**WELWYN HATFIELD BOROUGH COUNCIL
EXECUTIVE DIRECTOR - PLANNING, PUBLIC PROTECTION AND GOVERNANCE**

DELEGATED APPLICATION

Application No: 6/2021/2211/EM
Location: 52 Bridge Road Welwyn Garden City AL8 6UR
Proposal: Construction of 2x two-storey detached houses and associated parking and access on the land to the rear of 52 & 54 Bridge Road.
Officer: Mr James Homer

Recommendation: Refused

Project: RO Bridge Road, 52&54 AL8 6UR
Client: Mr M. Tabrizi
Title: Proposed Site Plan - No.52
Scale @ A1: 1 : 100
Drawing No: 1644.EM2.02

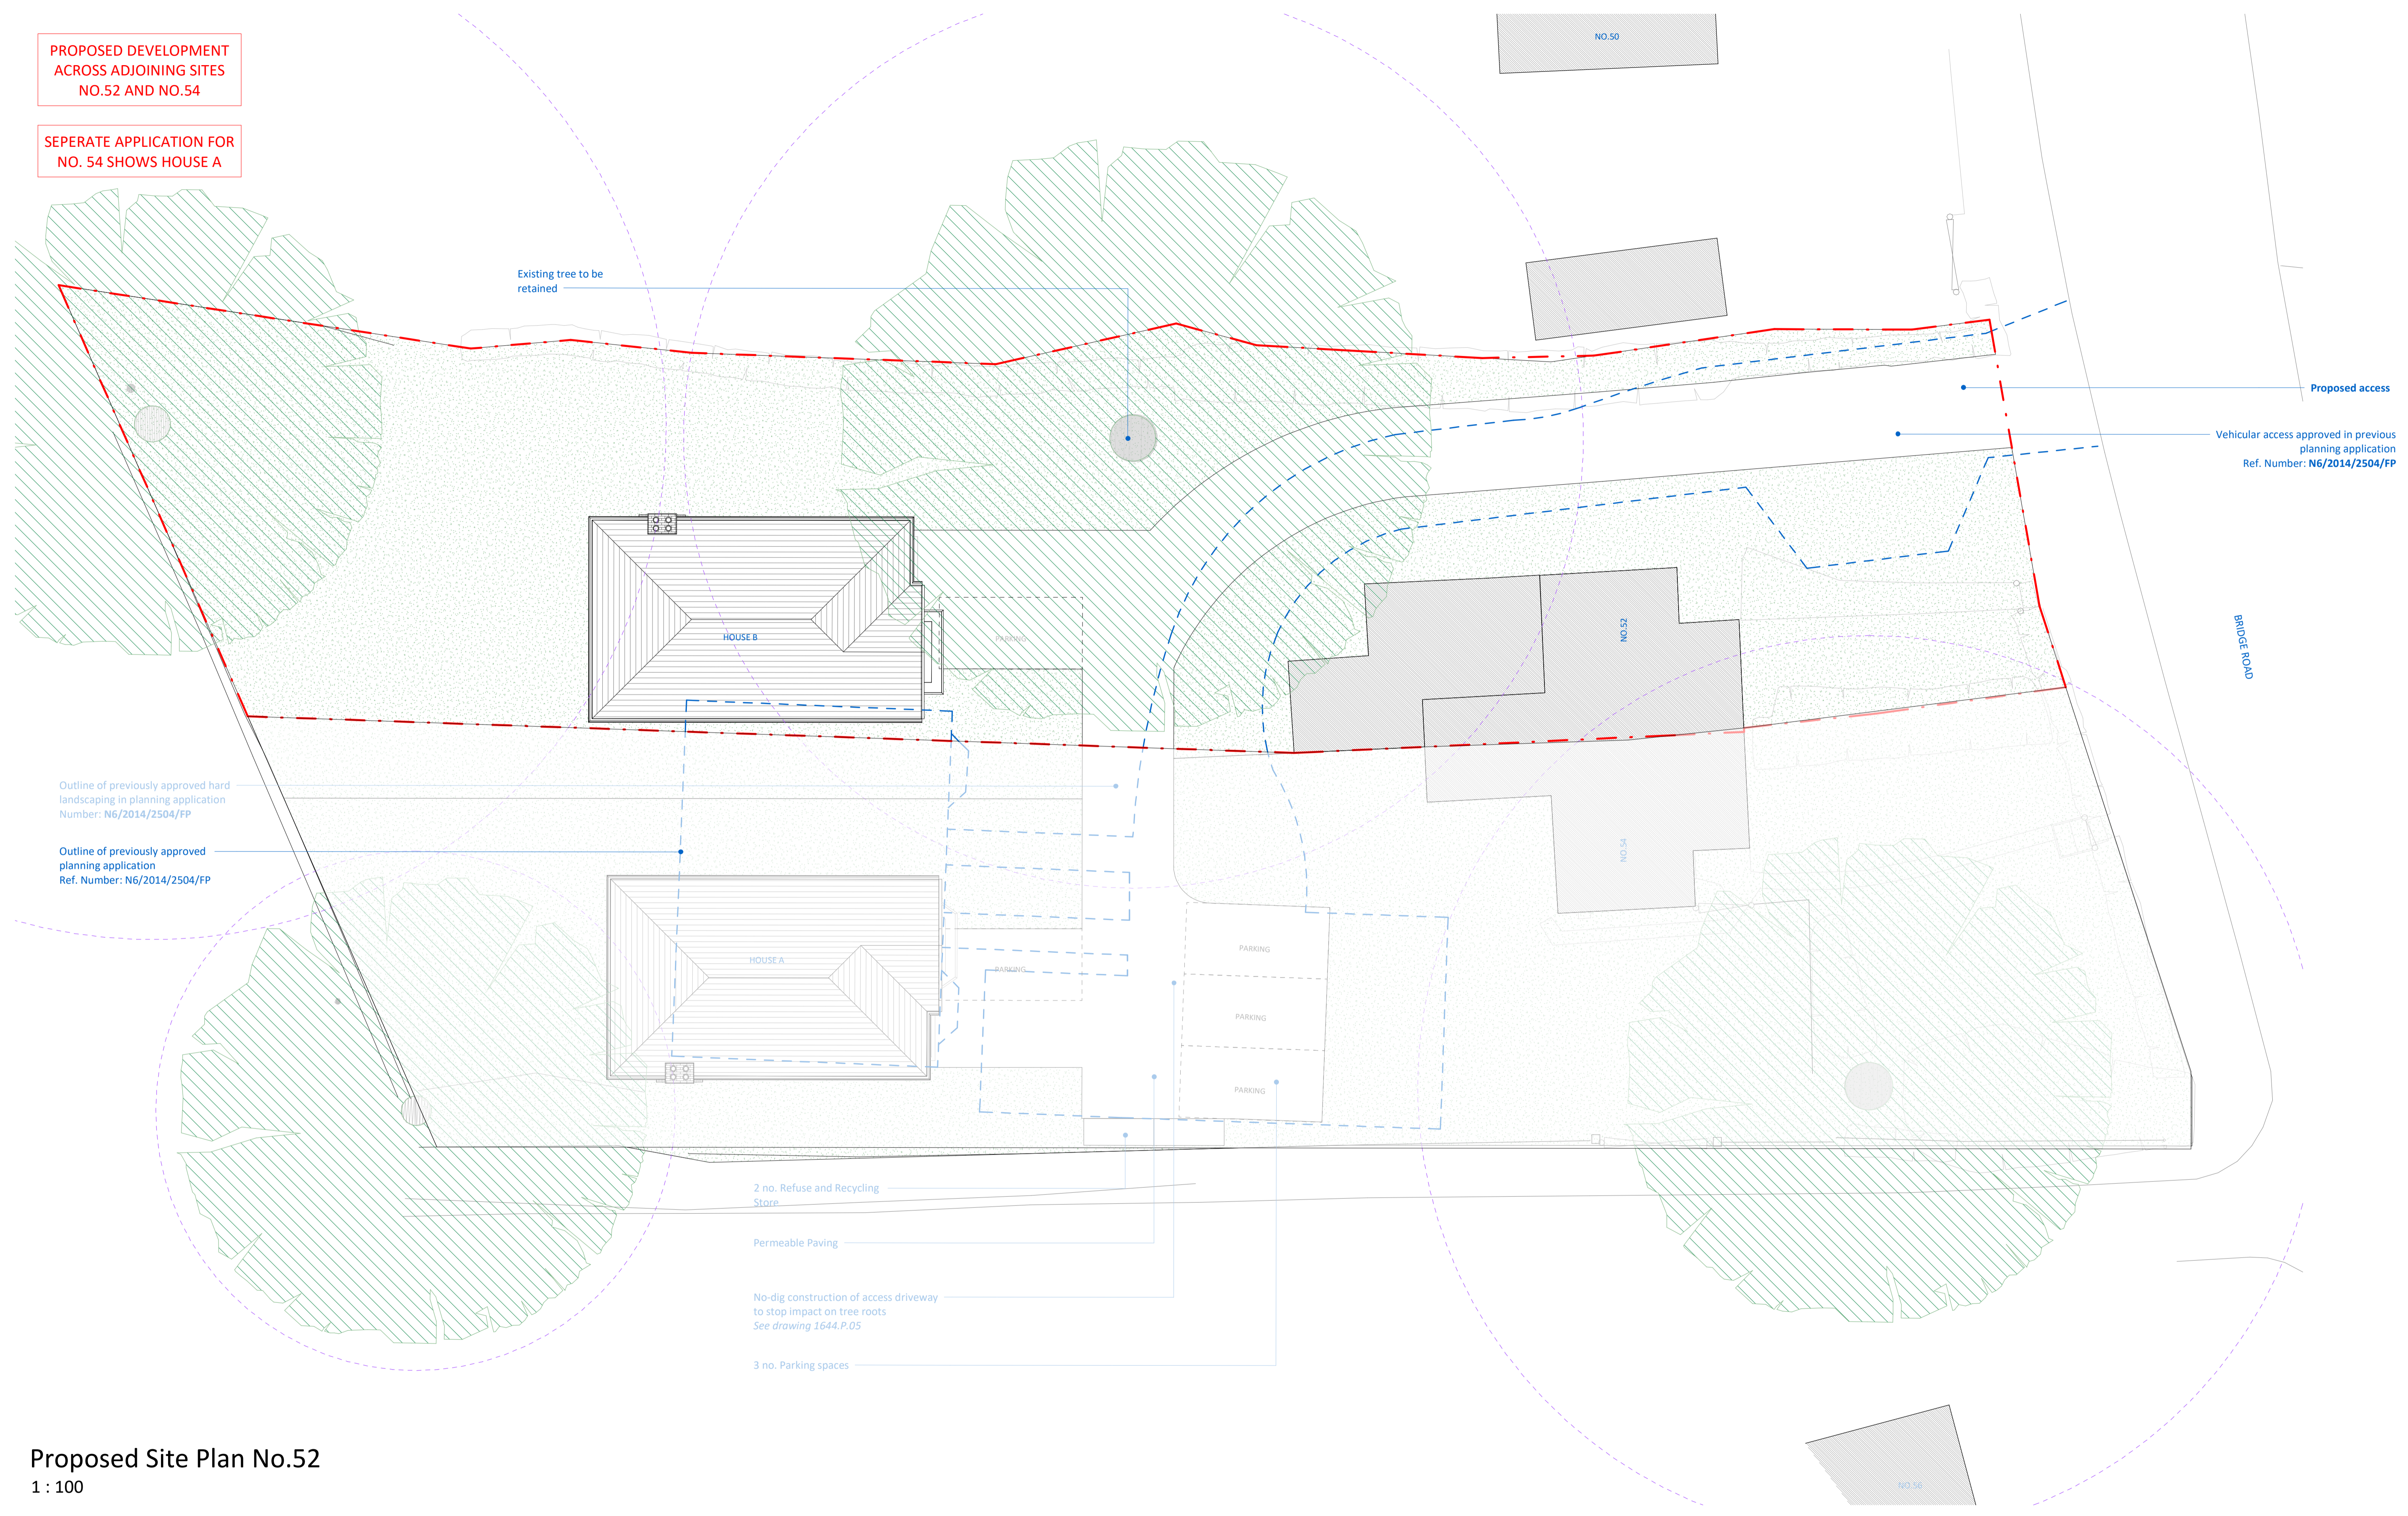
| Relevant Policies | |
|---|--|
| Design (form, size, scale, siting) and Character (impact upon amenities and values of Garden City) | <p>Policy EM2 of the Estate Management Scheme looks to protect the planned layout of the Garden City by ensuring that proposals for new buildings and structures respect the visual appearance of the area in terms of their siting and scale so they do not result in visually over prominent or discordant additions. In addition, all applications for new buildings should not harm the residential amenity of adjoining occupiers and the immediate area.</p> <p>The existing property is semi-detached with a large rear garden that backs onto the edge of Sherrardspark Wood. The surrounding area is predominantly residential also with large rear gardens. This part of the Garden City is largely characterised by a formality of layout and integration of soft landscaping and woodland within the built form. This gives the locality a relatively spacious character and appearance, which this property is in keeping with.</p> <p>Within the current gardens of no.52 the application proposes the following:</p> <ul style="list-style-type: none"> - Creation of a driveway to the front and side of the exiting property to access the proposed new dwelling (and dwelling proposed for the rear garden of no.54). - The erection of a three bedroom detached property. <p>The proposed house to be erected within the current rear garden of no.52 would feature a clay tiled hipped roof with a front gable projection with brickwork finish at ground floor and timber cladding finish at first floor. Conservation casement windows are proposed for the front and side elevations and first floor at the rear. The application proposes a timber front door and conservation style French doors with side lights at the rear.</p> <p>Despite the sympathetic design, the proposed building would appear out of place within the area as there are no properties set back behind the existing properties fronting Bridge Road. As a result, the proposed dwelling, together with the existing dwelling, would appear excessive, resulting in the site appearing overdeveloped and out of keeping with the immediate character of the area.</p> <p>Furthermore, gardens are considered an important component of the Welwyn Garden City and create important open space between homes and amenity areas. The sub-division of this plot would result in a significant loss of garden to the front and side of 52 Bridge Road and the erection of a large house to the rear would upset the balance of the open space between the houses along Bridge Road and the edge of the woodland to the rear of the site. Ultimately, the proposal would result in a more cramped site that is out of keeping with the area resulting in a detrimental impact on the spacious character and appearance of the locality as a whole.</p> <p>Despite the sympathetic design, the proposed new dwelling to the rear of no.52 would not respect the visual appearance of the area in terms of its siting and scale and would result in visually over prominent and discordant addition. This is exacerbated by the proposal for a similar dwelling within the rear garden of 54 Bridge Road.</p> |

| | <p>In terms of neighbour amenity the siting of the proposed dwelling would introduce a significant structure to the rear of No.52. However, the separation distance between the properties and boundary screening from existing vegetation is such that it is not considered the proposed development would result in a detrimental loss of light or appear unduly dominant. Whilst there are side windows proposed within the dwelling, these are shown to serve bathrooms and therefore can be conditioned to be obscure glazed if necessary.</p> |
| <p>Landscaping issues (incl. hardstandings)</p> | <p>Policy EM4 seeks to retain the appearance of the Garden City while accommodating the increased pressure for vehicle hard standings due to the rise in car ownership over recent years. In doing so, Policy EM4 states that proposals to construct hardstanding should retain or create sufficient soft 'green' landscaping to help preserve the character of Welwyn Garden City. In addition, works must not result in the loss of any existing hedgerows or landscaping along the boundary other than the minimum required to access the hardstanding.</p> <p>The proposal includes the creation of a driveway to access the proposed developments to the rear of 52 and 54 Bridge Road. The driveway would utilise an existing opening and access to no.52 and continue along the side of no.52 to the rear of the site. The proposed driveway would increase the level of hardstanding to the side of no.52 but not to an extent that can be considered harmful to the property.</p> <p>Policy EM3 of the Estate Management Scheme states that works to hedgerows will only be allowed where the works would not result in the loss of landscaping which would harm the character and amenities of the area and where sufficient justification for the works has been given.</p> <p>The proposed plans indicate that at least one tree within the existing rear garden of no.52 would need to be felled. No justification for its removal has been given or replacement planting proposed to compensate for the loss. The proposed felling of the tree may result in harm to the verdant setting of the property and the character of the area. In addition, the application lacks the submission of an Arboricultural report necessary to demonstrate that the proposed works would not result in unacceptable harm to TPO trees on the site.</p> |
| <p>Despite the sympathetic design, the proposed new dwelling to the rear of no.52 would not respect the visual appearance of the area in terms of its siting and would result in a visually over prominent and discordant addition to the rear of the existing property that would result in harm to the character of the site and wider area of Bridge Road. This is exacerbated by the proposal for a similar dwelling within the rear garden of 54 Bridge Road.</p> <p>As a result, the application fails to comply with Policy EM2 of the Estate Management Scheme.</p> | |

1. Despite the sympathetic design, the proposed new dwelling to the rear of no.52 would not respect the visual appearance of the area in terms of its siting and would result in a visually over prominent and discordant addition to the rear of the existing property that would result in harm to the character of the site and wider area of Bridge Road. This is exacerbated by the proposal for a similar dwelling within the

rear garden of 54 Bridge Road. As a result, the application fails to comply with Policy EM2 of the Estate Management Scheme.
